Your ref:
Our ref: 21/00167/F
Please ask for: Miss Sandra Homcenko
Direct dial: 01553 616824
Direct fax: 01553 616652
E-mail: borough.planning@west-norfolk.gov.uk

Details: **Demolition of existing lean to sunroom and rebuild with blockwork and render and pitched roof. at 11 Foresters Avenue Hilgay Downham Market Norfolk PE38 0JU**

I have received a planning application as detailed above but cannot process it until I receive some more information:

EXISTING PLAN VIEW SCALE 1:50

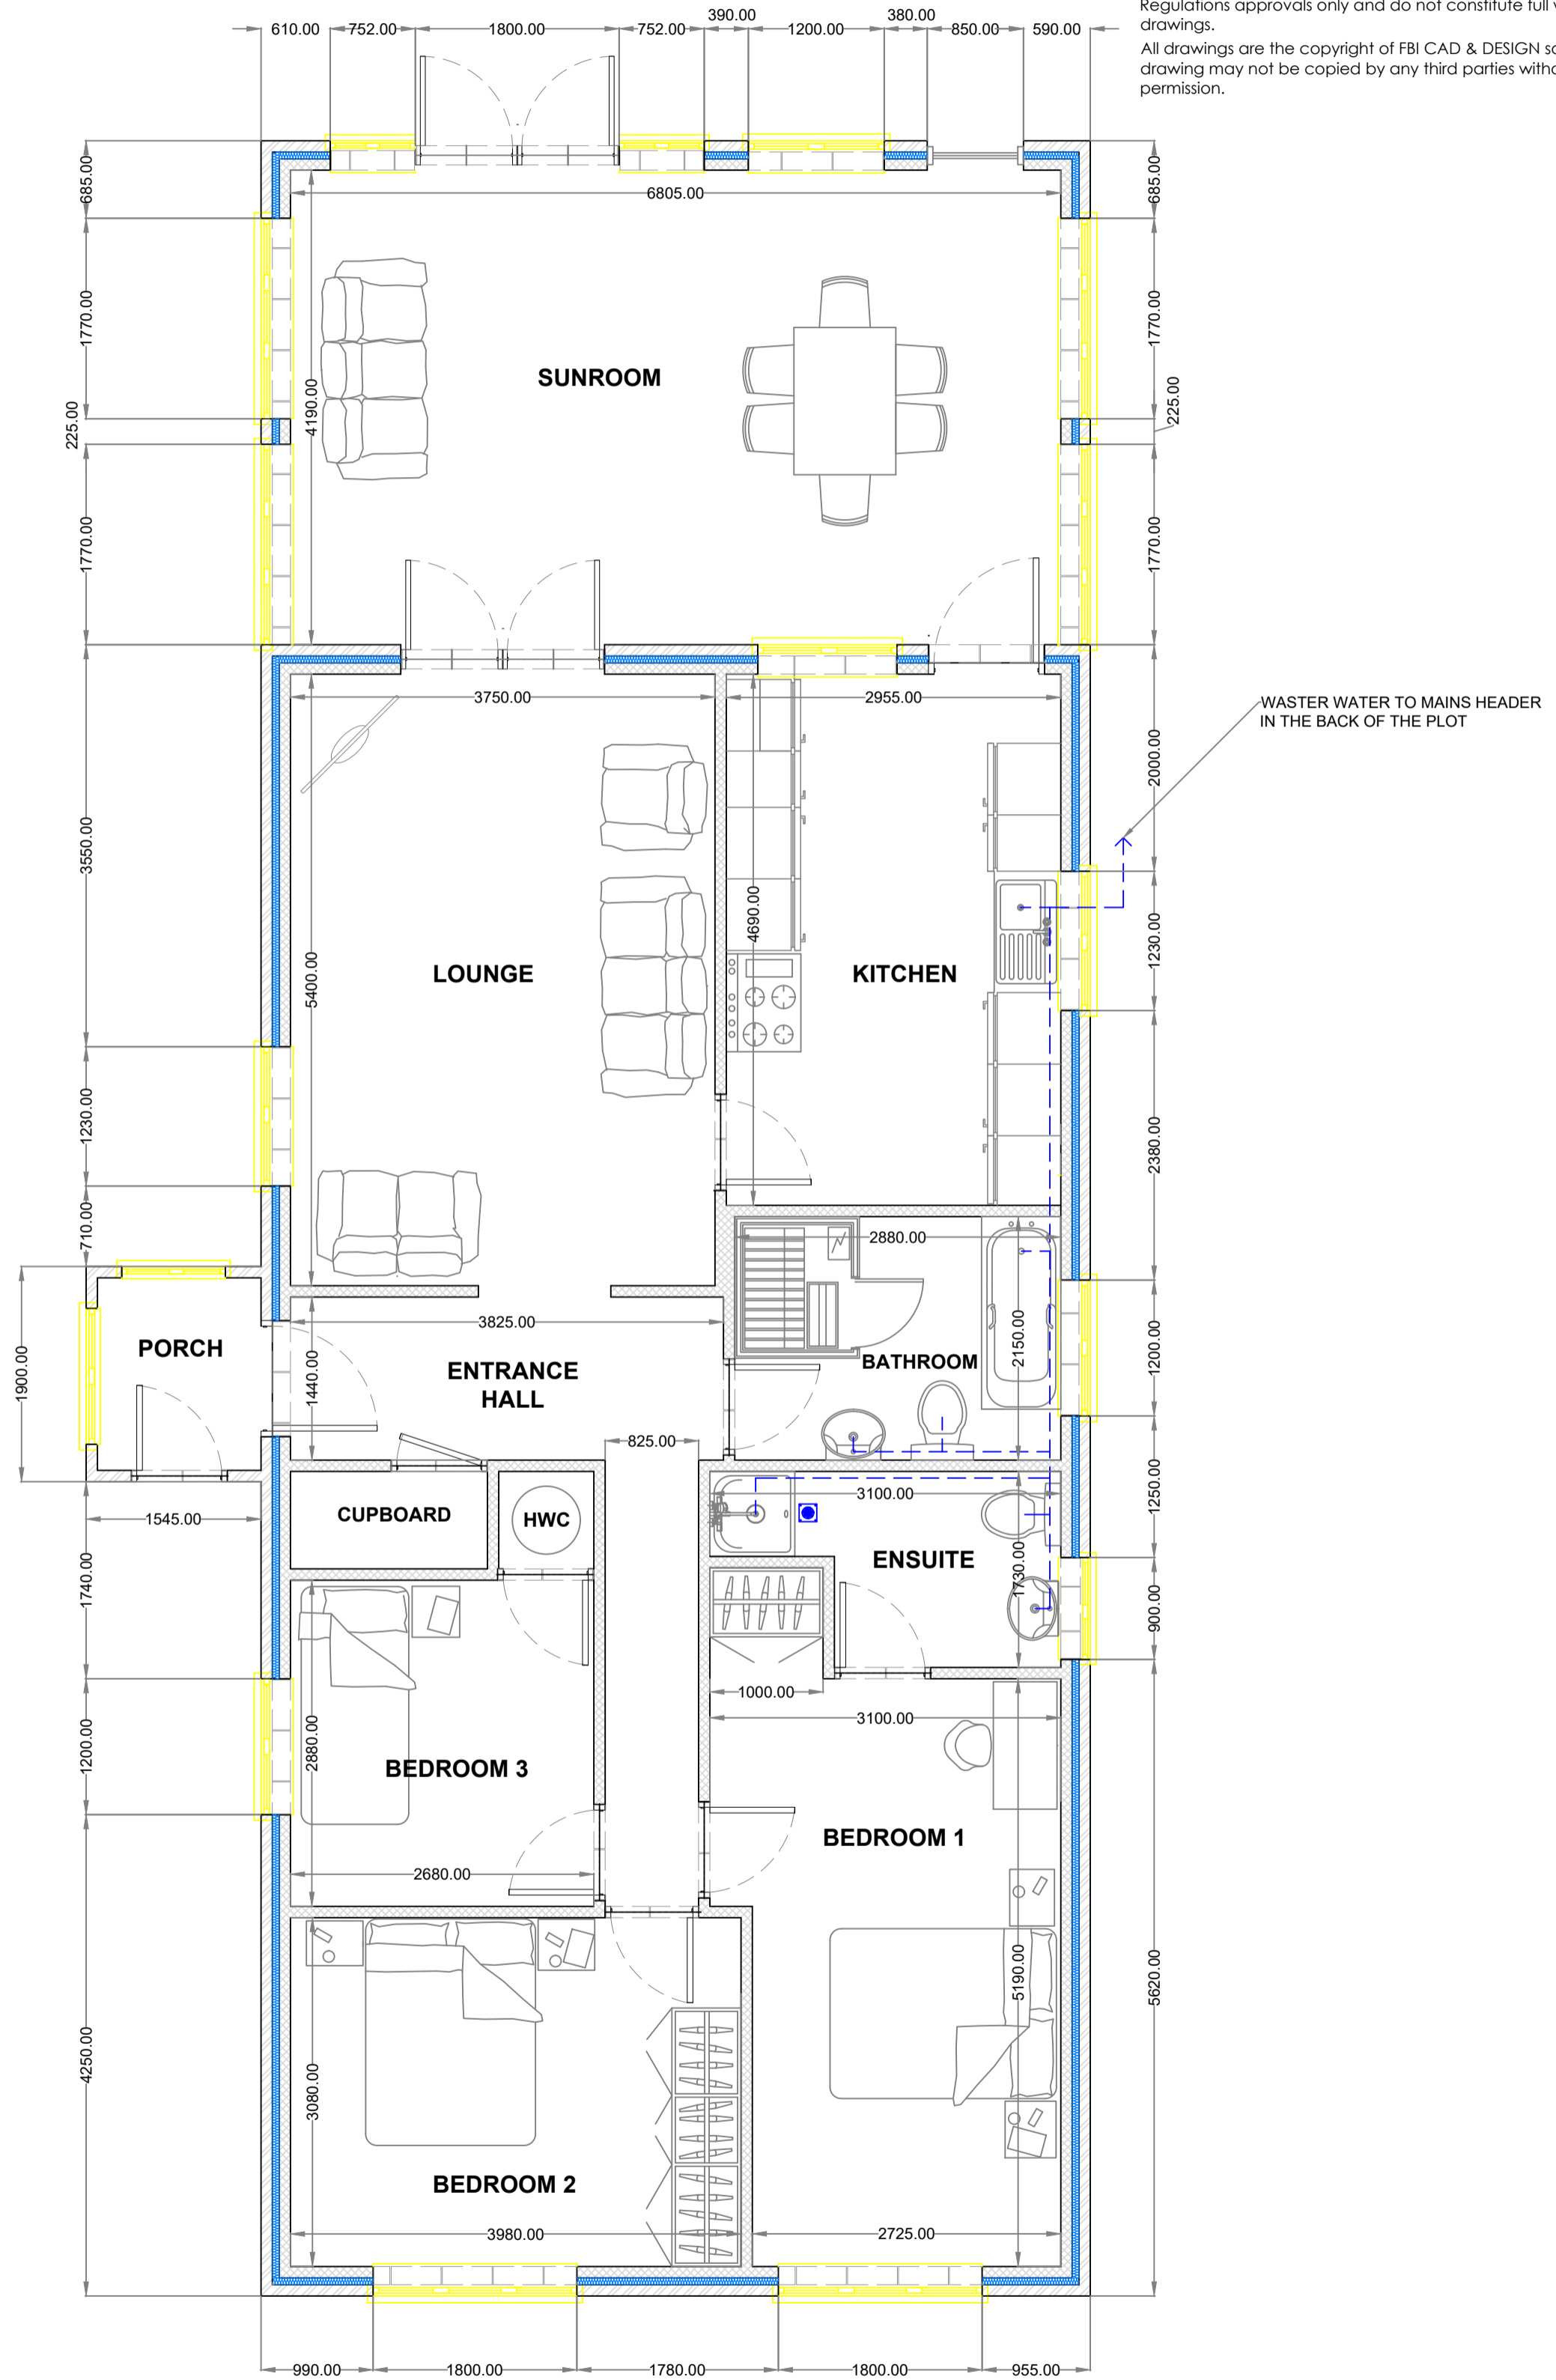
1. It appears that there is a window missing for porch entry on the Existing Floor Plan.
